Submission by M Crookes following the open floor hearing on 25th June 2024

Simplistic Synopsis of Project

ELEVATION LOOKING NORTH

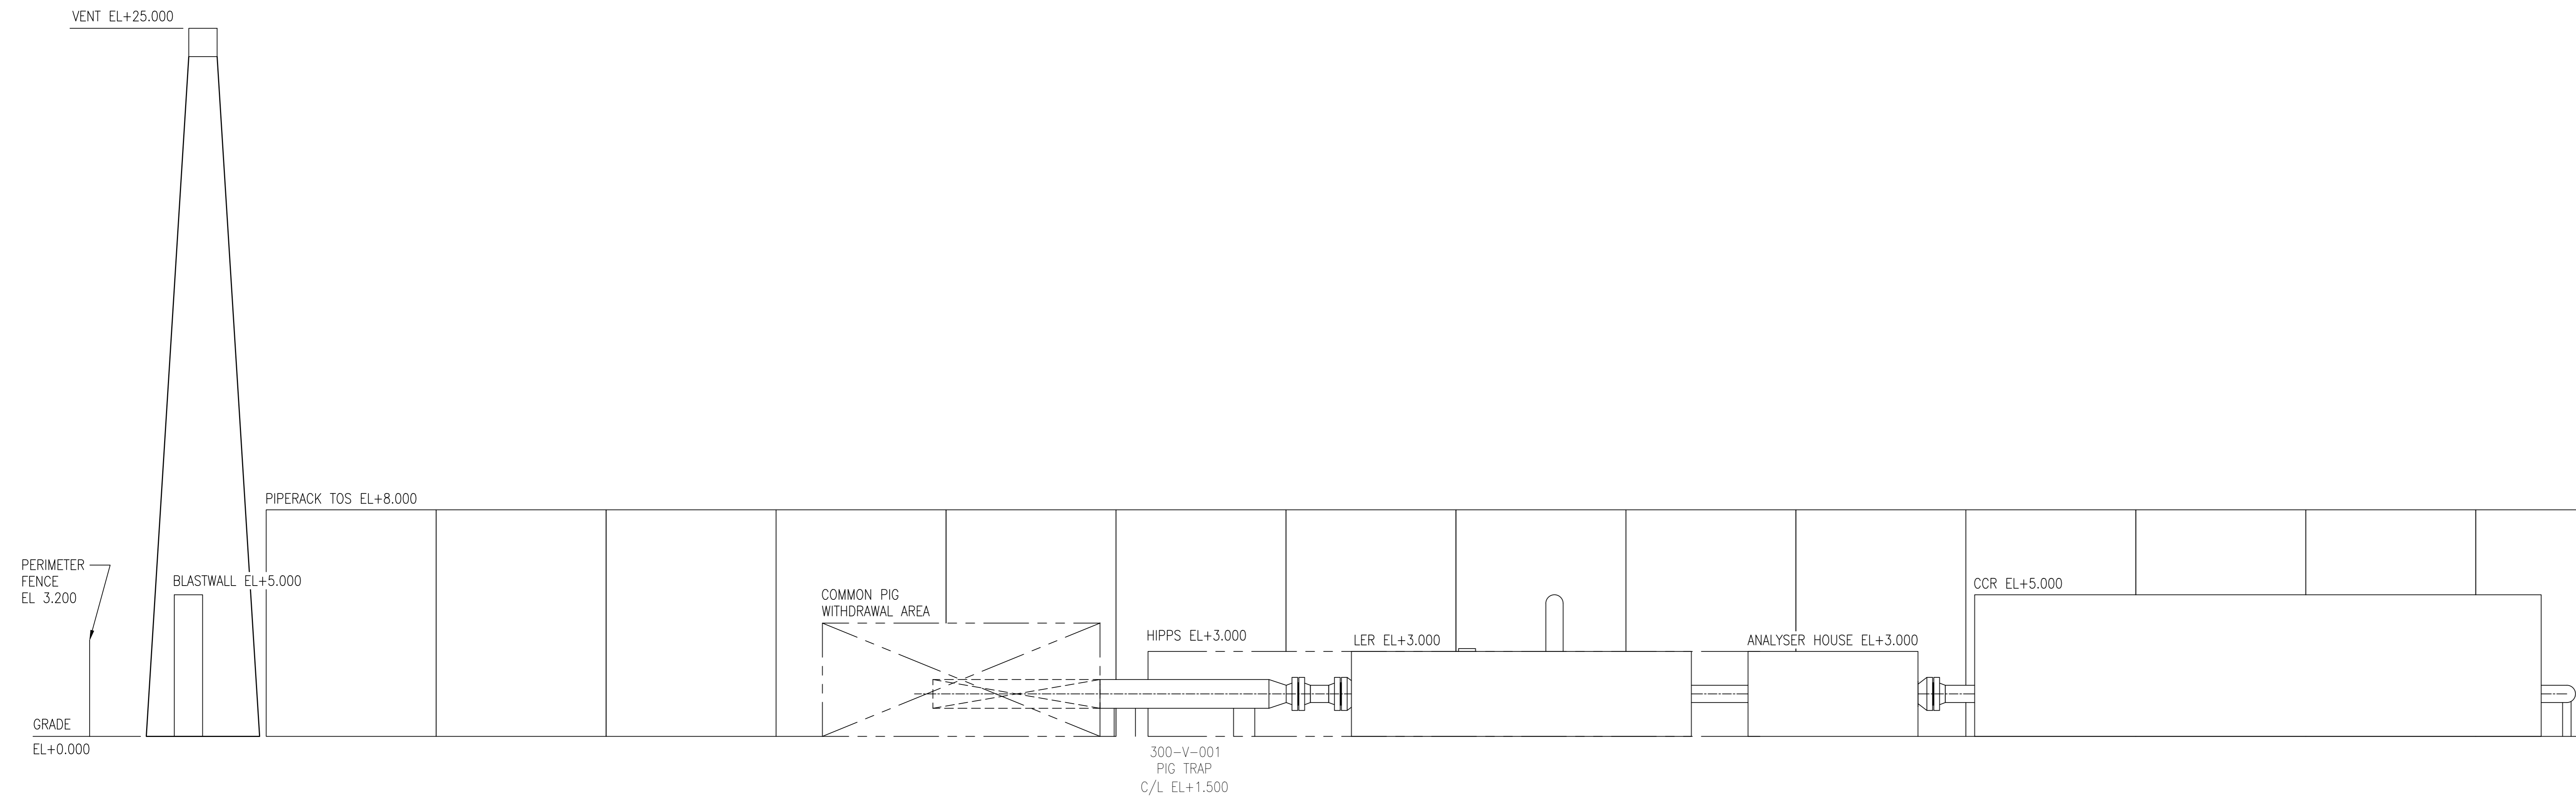
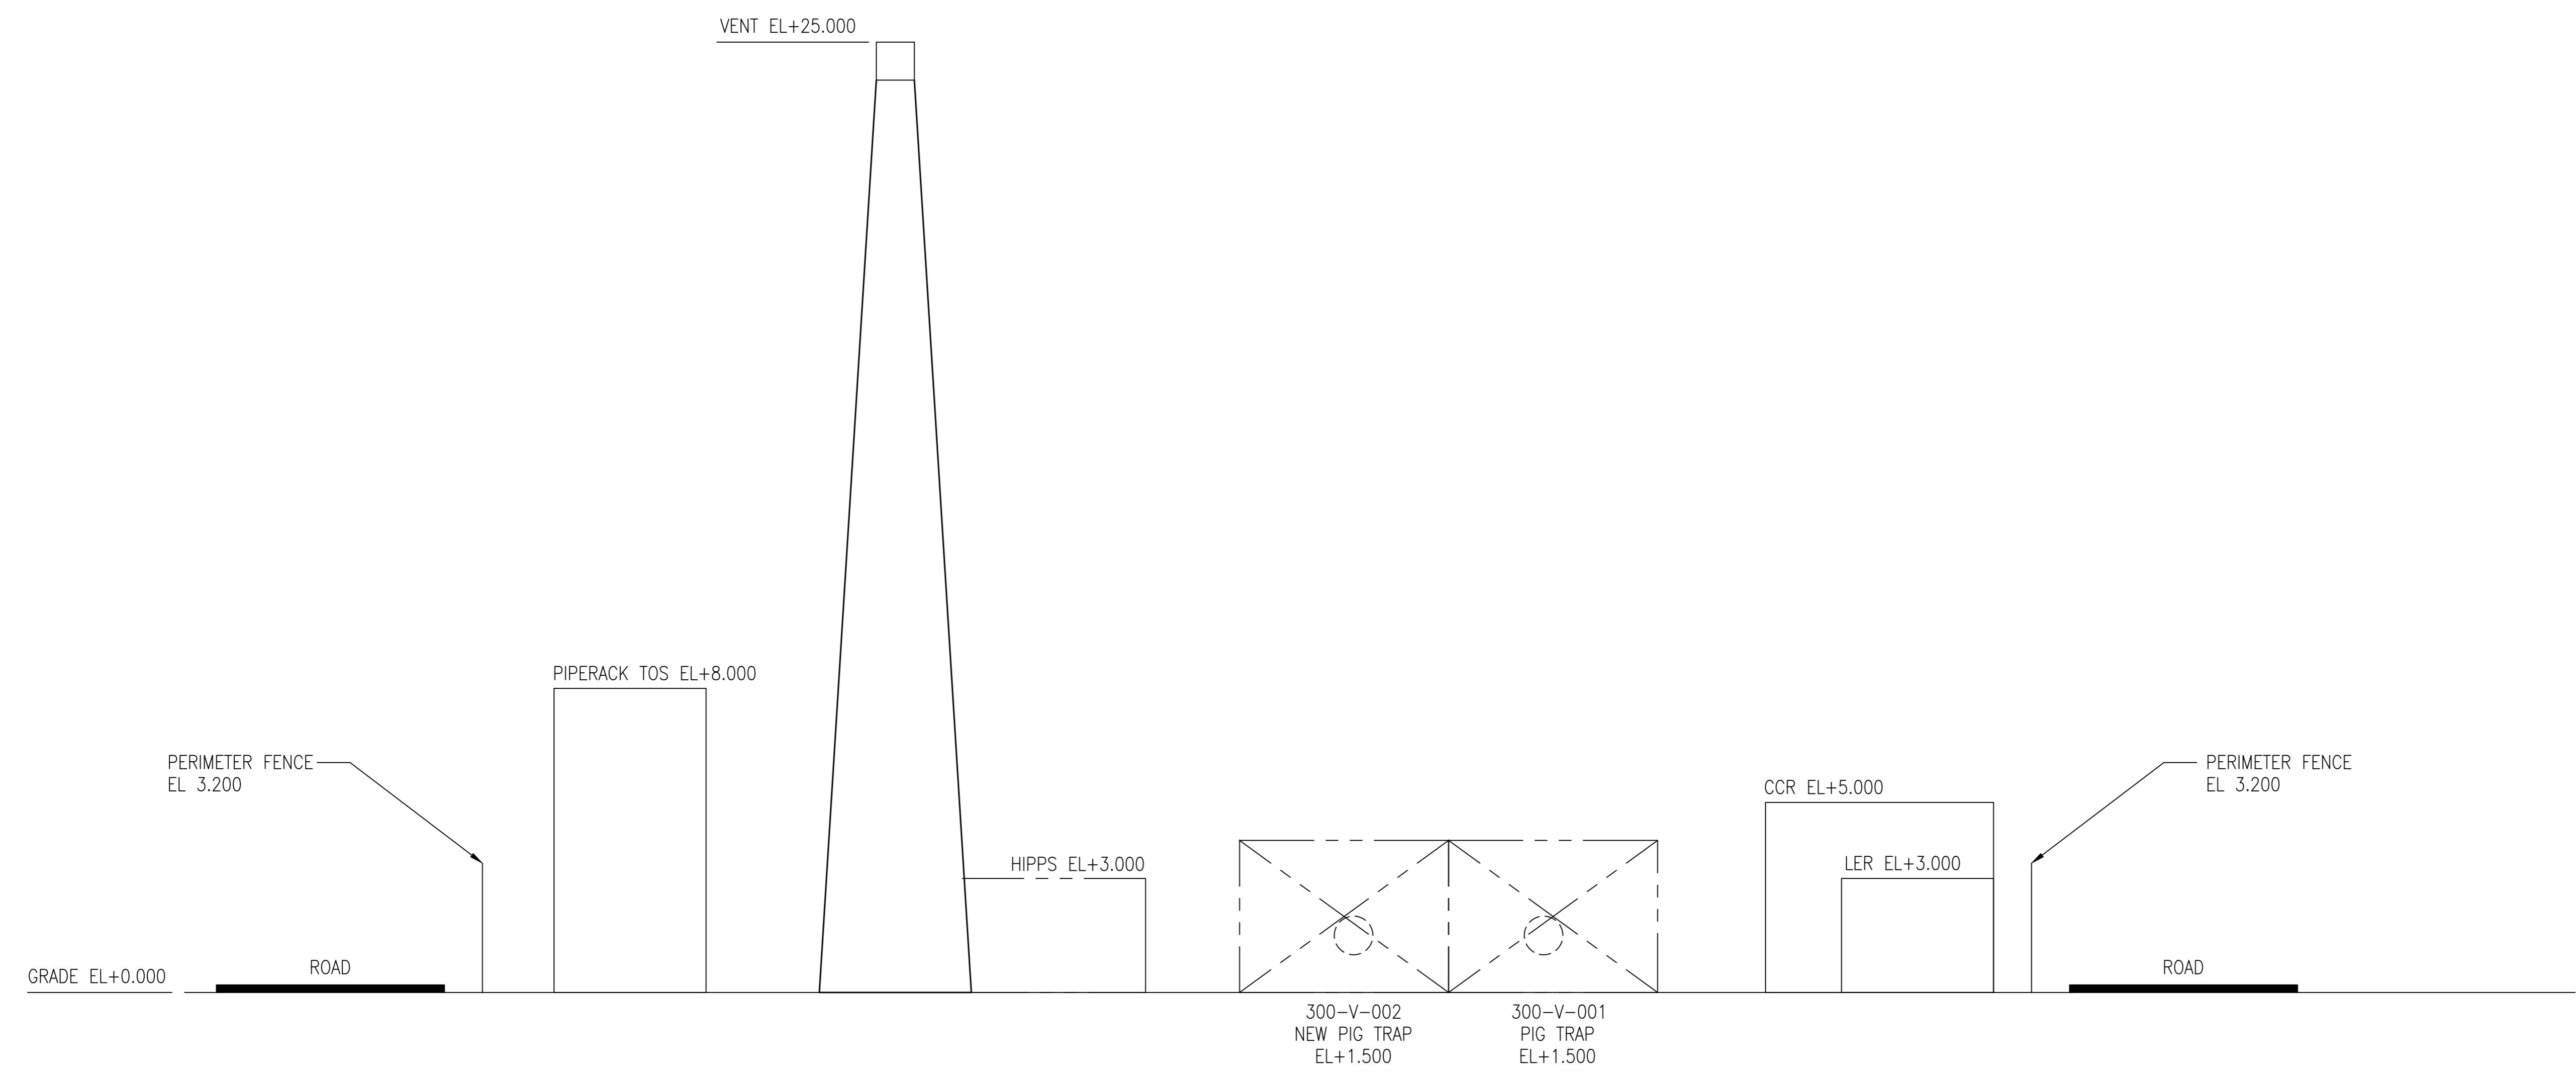
Venting: What will programmed venting look like? What will emergency venting look like? As noted in the remarks by Vince Loy on behalf of Guardians of the East Coast, an emergency depressurisation could take days. The eyesore 25m vent stack (only half as tall as the 50m pylons that everyone is up in arms at within Lincolnshire) could have to operate for days on end in the event of an emergency. It would take 23.33 days to fully evacuate 10,000 tonnes of CO₂ at 5 kilos per second. Obviously if the pipeline was vented from both ends i.e. Immingham and Theddlethorpe it would only take around 11.5 days. Can Chrysaor guarantee that sufficient wind will be available to dissipate the resultant CO₂ (and potentially other contaminants) to safe levels.
